Planning Application

No. 3/2024/0464

**SITE LOCATION PLAN
AREA 2 HA
SCALE 1:1250 on A4
CENTRE COORDINATES: 376385, 434938**

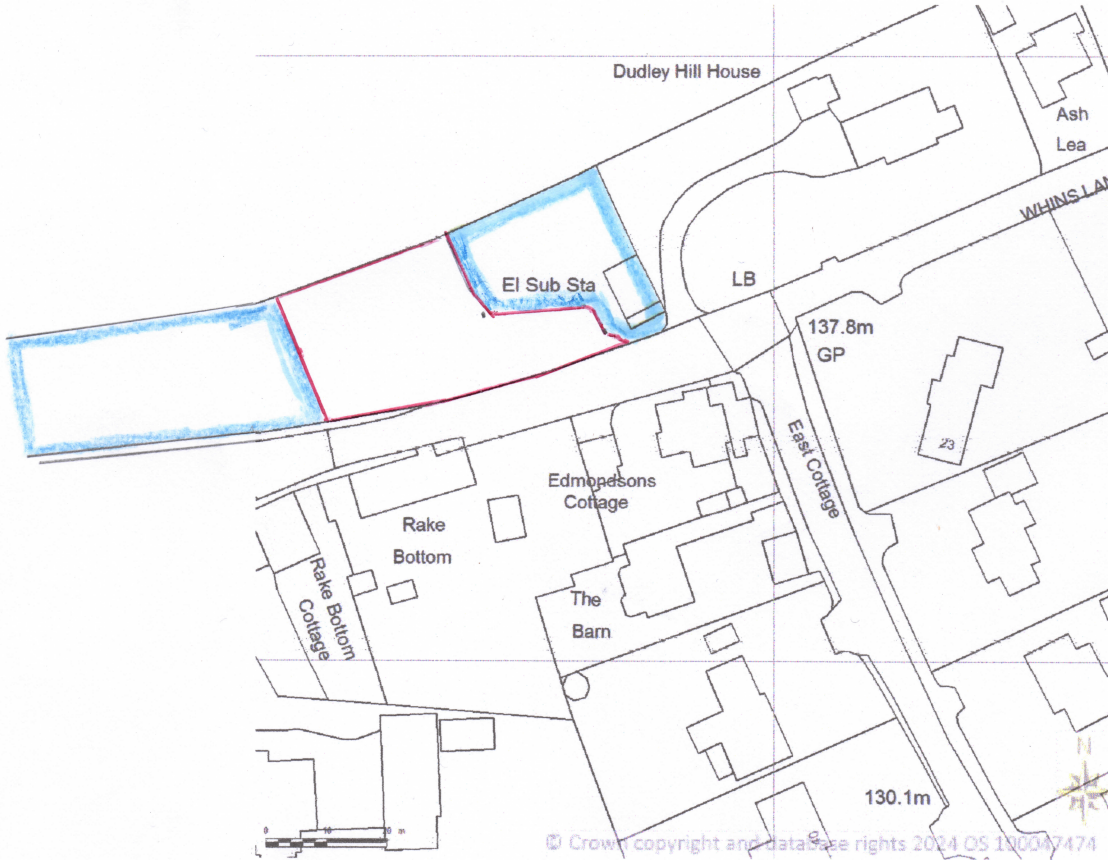
There is an old well to
the right of the entrance,
which I don't see marked
on the plan.
